REQUEST

Current Zoning: N1-A (single family residential)
Proposed Zoning: R-8MF(CD) (multi-family residential, conditional)

Approximately 42.46 acres located along the north side of Rocky River Road, west of Back Creek Road, and southeast of John Russell Road.

The petition proposes to allow up to 200 single family attached (townhome) residential units on a property containing an existing single-family home that will remain and is located outside of the rezoning boundary in East Charlotte.

SHEET NUMBER  
RZ-01

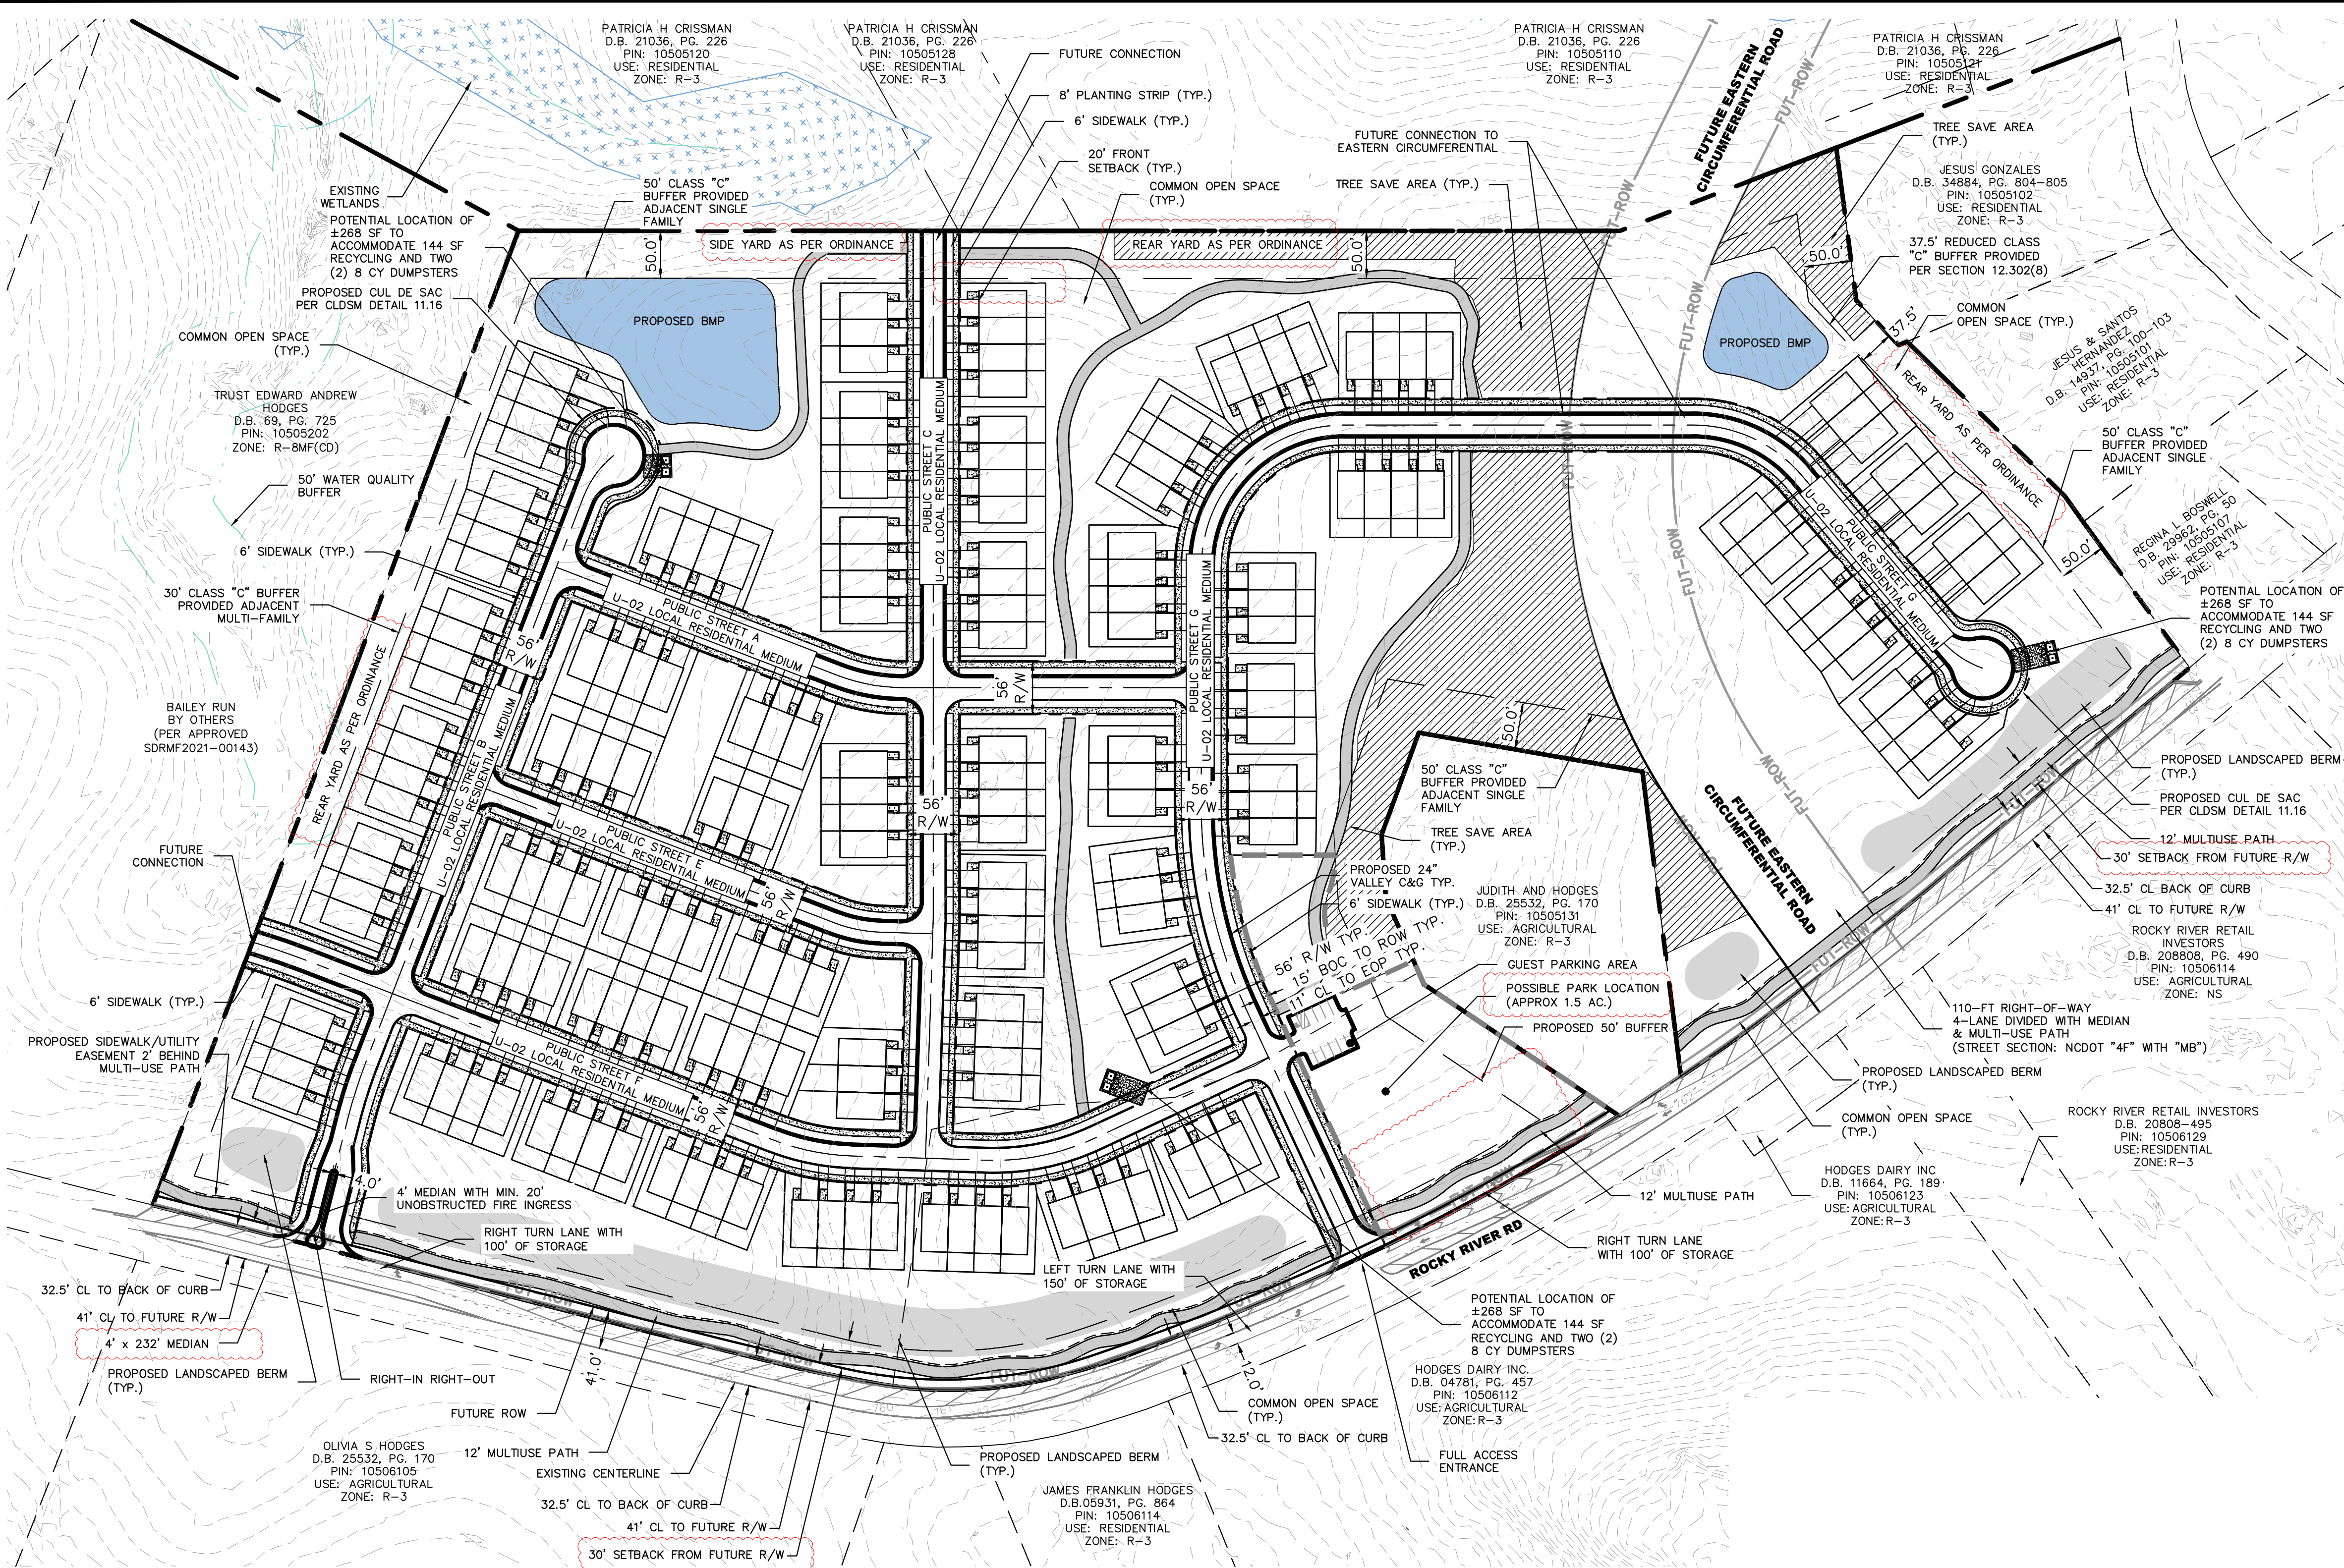
21. Development Data Table references the 50-foot Class C buffer, but not the 30-foot Class C buffer provided adjacent multi-family.
22. ~~New comment resulting from revised site plan dated 5/18/2023:~~ Previous site plans submitted state total 38.25 acres, while most recent plan states 42.46 acres. Please confirm which acreage is correct. Addressed

23. ~~New comment resulting from revised site plan dated 5/18/2023:~~ Add to Site Data Table—"15 ft. setback per Section 9.303(19)(f) of the zoning ordinance." Addressed
